From: Nicola Moore on behalf of Planning.Responses
Sent: 23 December 2019 09:34
To: Planning Scanning
Subject: FW: Application Ref: R/220/19/PL - 2 Ash Lane, Rustington
Attachments: 191104 Applicant Correspondence.pdf

From: Aarti O'Leary
Sent: 04 November 2019 14:08
To: 'Richard Castro-Parker' [REDACTED]
Subject: Application Ref: R/220/19/PL - 2 Ash Lane, Rustington

- The proposed seating area does not use any of the pavement in front of the existing building;
- There is a solid partition between the application site and the entrance to the first floor offices;
- The proposals are such that patrons would not be able to spill out onto the pavement or congregate in front of the entrance to the first floor offices.

DRAWING STATUS	PLANNING
PROPOSED ELEVATIONS & EXTERNAL SEATING AREA

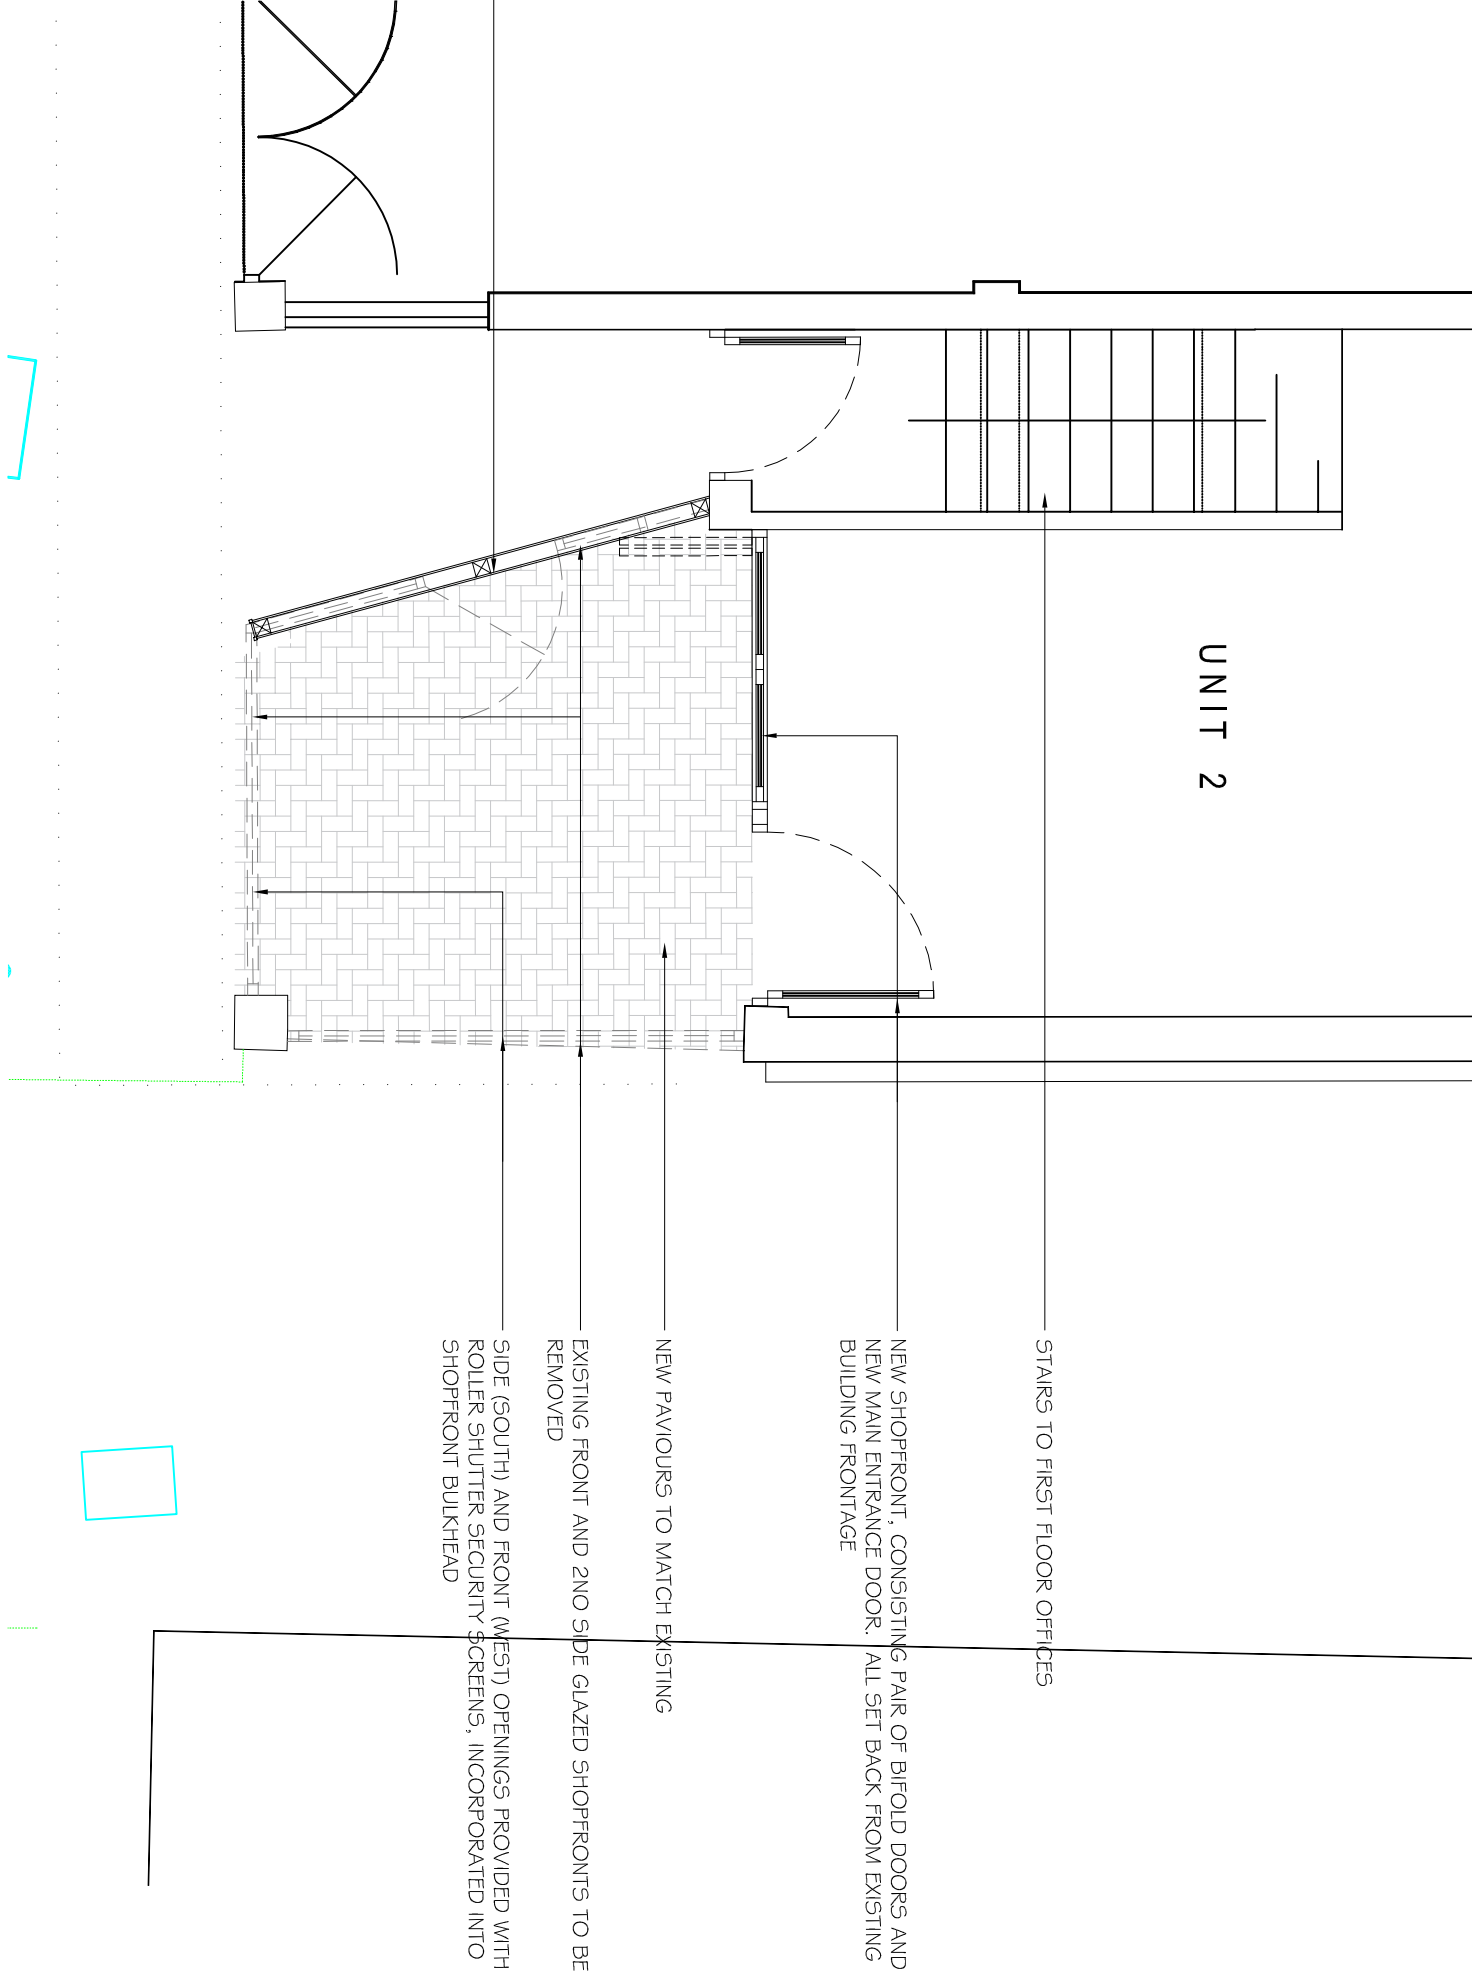
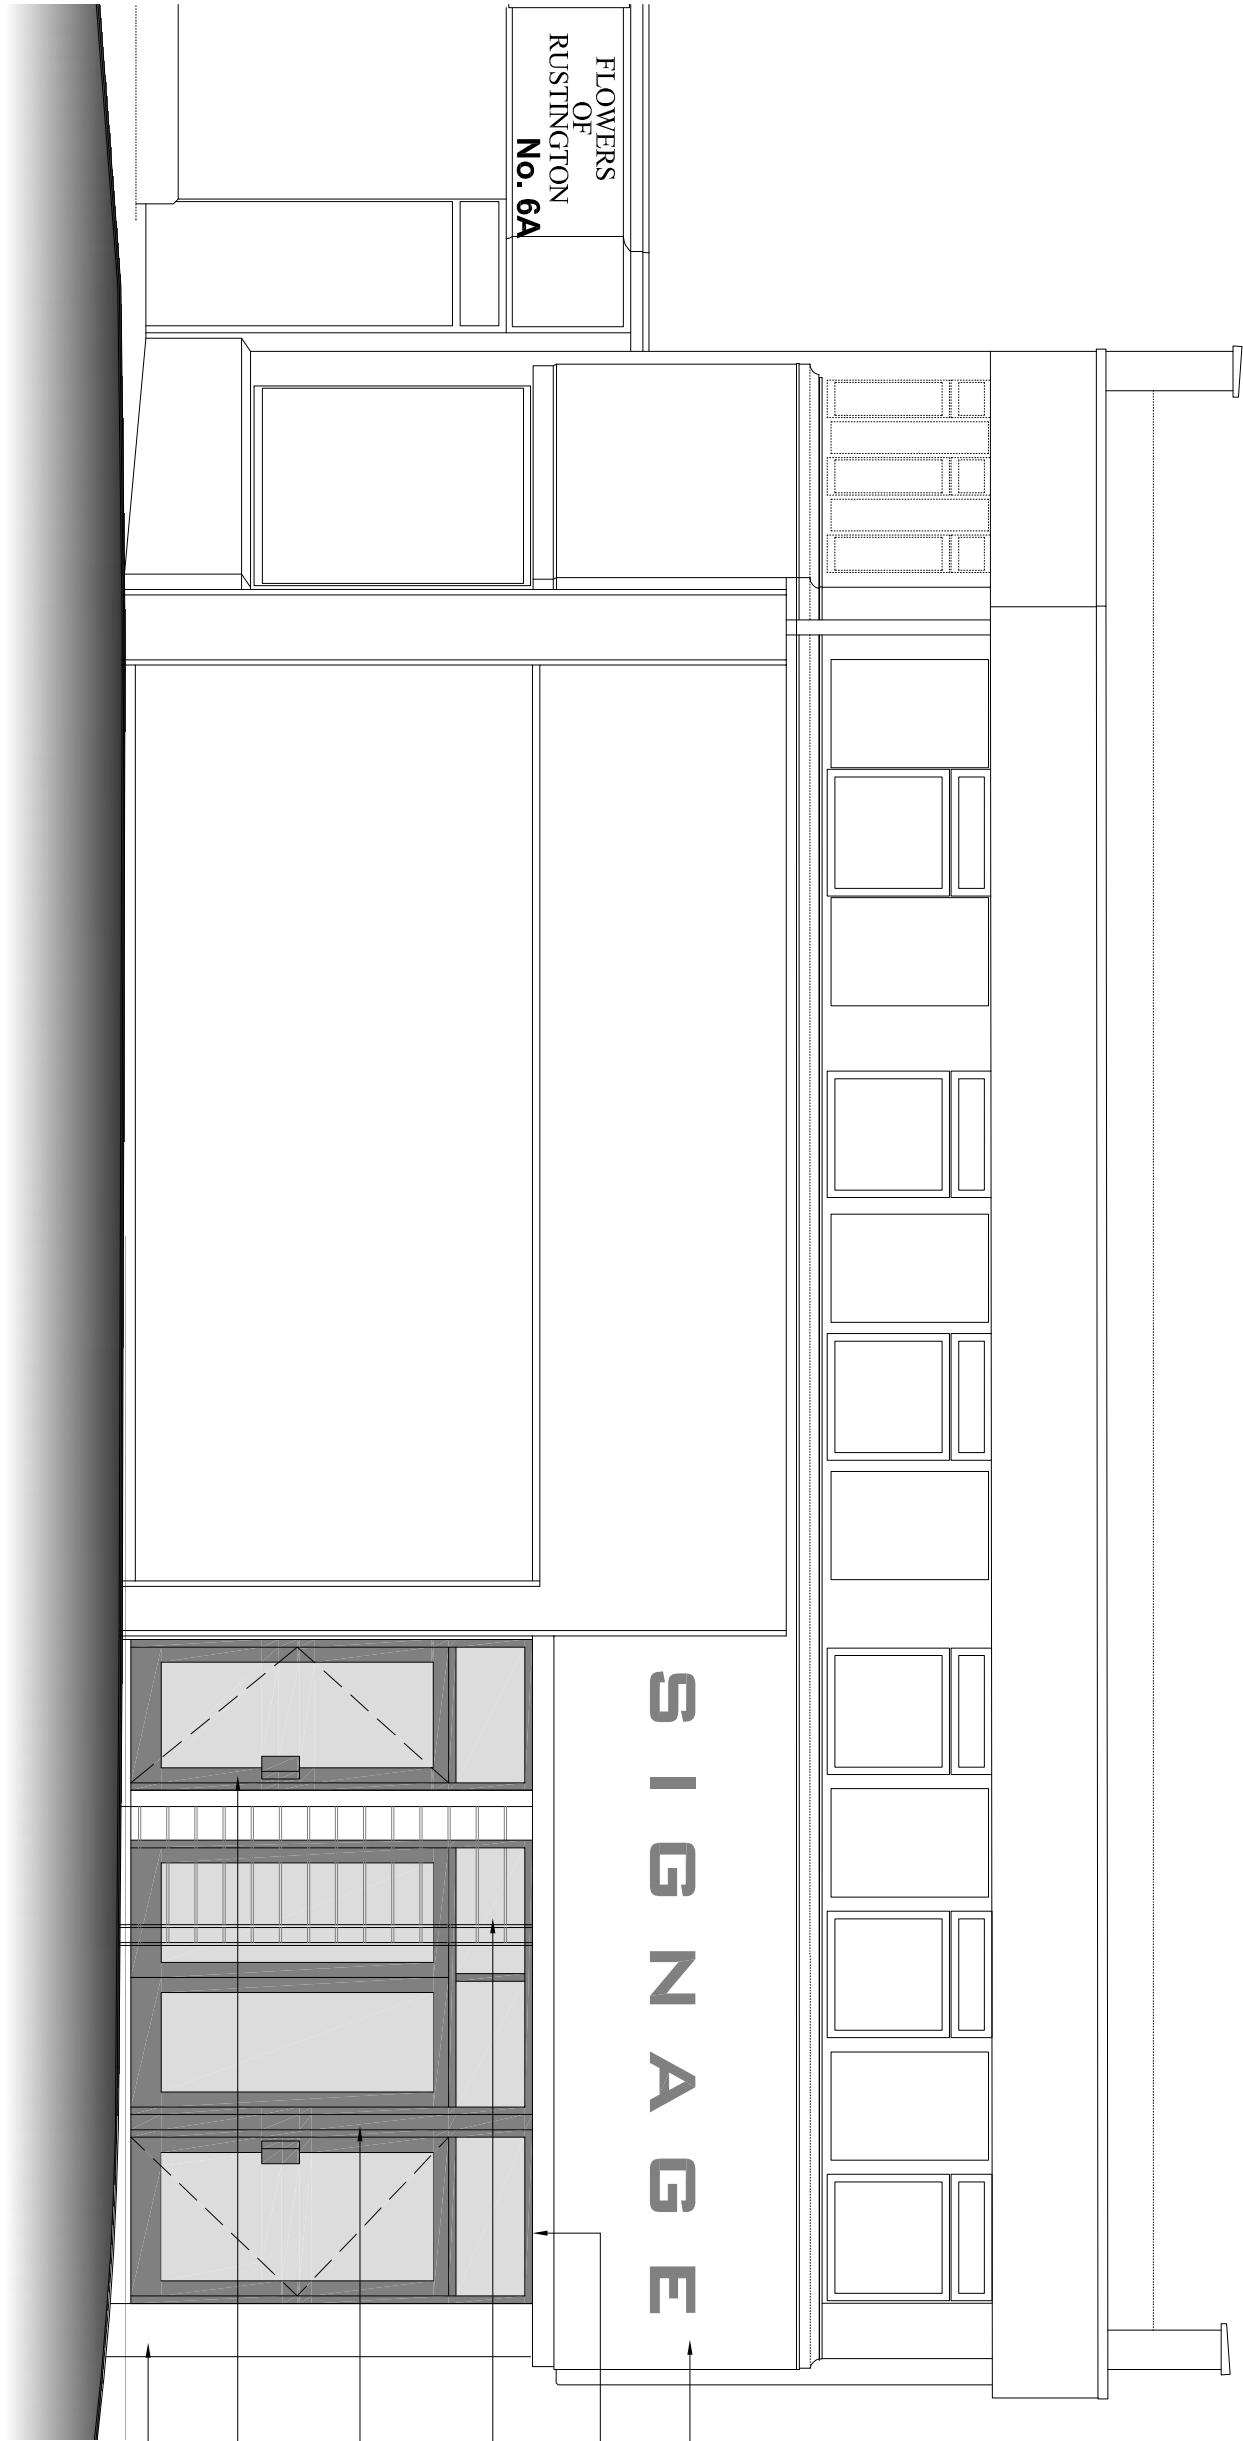
1. A "pavement seating" area is being created within the existing building and does not use any of the pavement in front of the existing building.
This is correct. the existing glazing of the shop front is being replaced by a covered trading area with the seating only in this area.
2. There is a solid partition between the building and our entrance (the wall currently with a door to the Halifax building).
Correct – this is being a hard frontage to prevent overspill as per the plan.
3. There will be barriers in front of the seating area (facing Ash Lane) to stop people spilling out onto the pavement and congregating in front of the entrance to our offices.

Correct – it will also have a roller shutter door to prevent homeless people front residing when out of hours.
